**RE: REQUEST FOR LANDOWNER'S CONSENT TO LODGE AN 'APPLICATION'
TO REQUEST TO MODIFY A MAJOR PROJECT'
REFERENCE NUMBER: LOC 8030
Address: Darling Walk, Darling Harbour**

**MODIFICATION TO MAJOR PROJECT 08-0093
DARLING WALK – PUBLIC DOMAIN**

On behalf Lend Lease Development, we write to request the Minister (or his delegate) modify the Project Approval 08-0093 under section 75W of the *Environmental Planning and Assessment Act 1979* as described below. The modification relates to the Harbour Street drop-off and pick-up lane off Harbour Street.

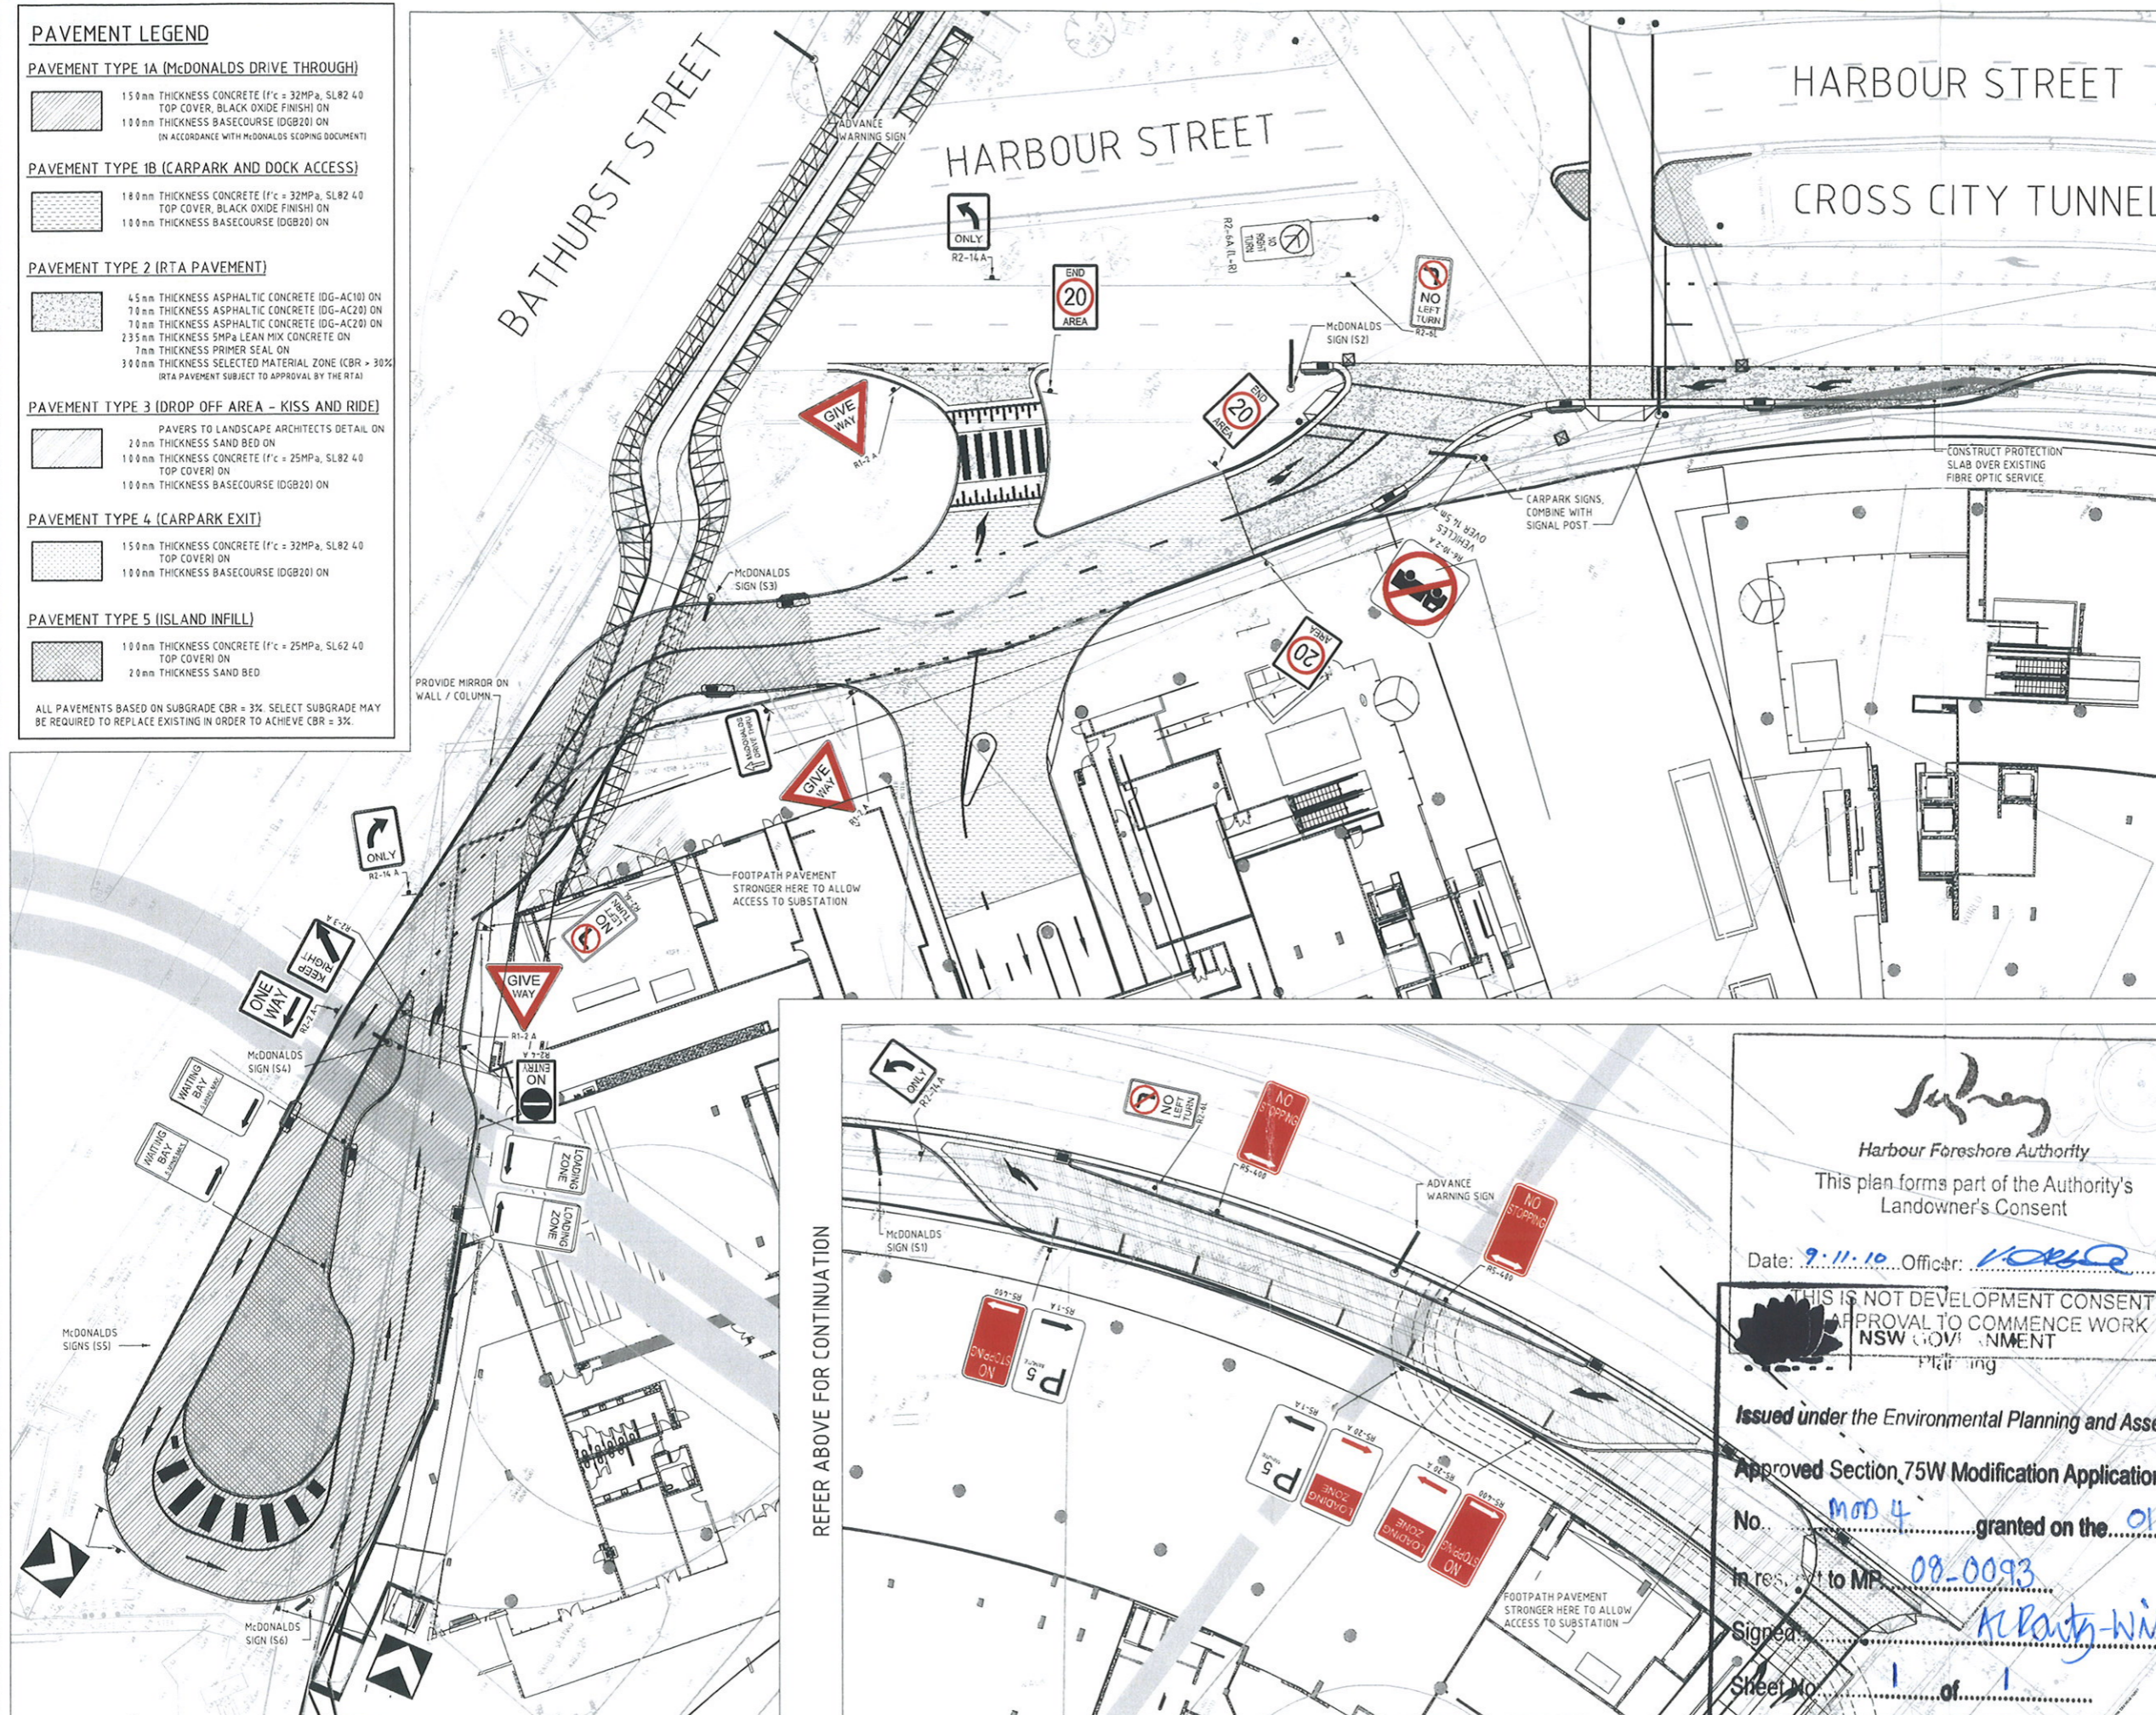
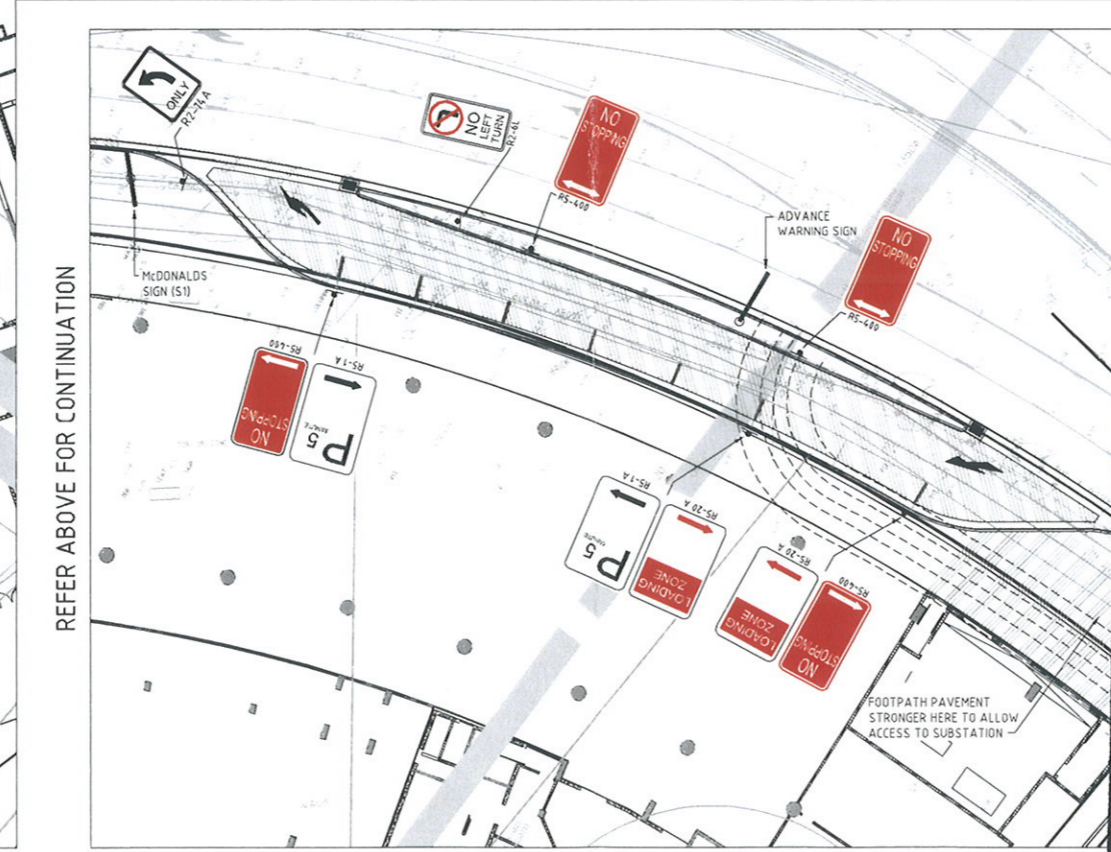
This modification proposes to extend the pick up and set down lane by 12m and provide a loading zone area within the lane.

It is proposed to provide a loading zone area as well as the passenger pick-up/ set down spaces as shown in **Figure 1** below. To accommodate the loading zone it is also proposed to lengthen the

pick-up/set down lane by 12 metres and to taper the median strip at each end to allow for trucks to satisfactorily use the drop-off lane. A plan of the proposed works is attached.

Whilst the current configuration of the lane provides space for five vehicles to pick up/ set down passengers, there is also a need to provide a loading zone space for the delivery of goods to the southern building. As shown on the attached works plan a loading zone area can be provided alongside the pick-up/set down space currently approved.

The lane will be appropriately sign posted as illustrated in **Figure 1** below and it is considered that the extension and partial change of use of this lane to a loading zone will not create any additional adverse impacts upon the traffic flow along Harbour Street beyond those considered in the original Project Application. This amendment is therefore considered to be acceptable.

E Architectural (or Design) Drawings prepared by Hyder Consulting and Itemised as follows			
Drawing Number	Revision	Name of Plan	Date
CD442065	09	Pavement, signage and line marking plan – Harbour Street	April 2008
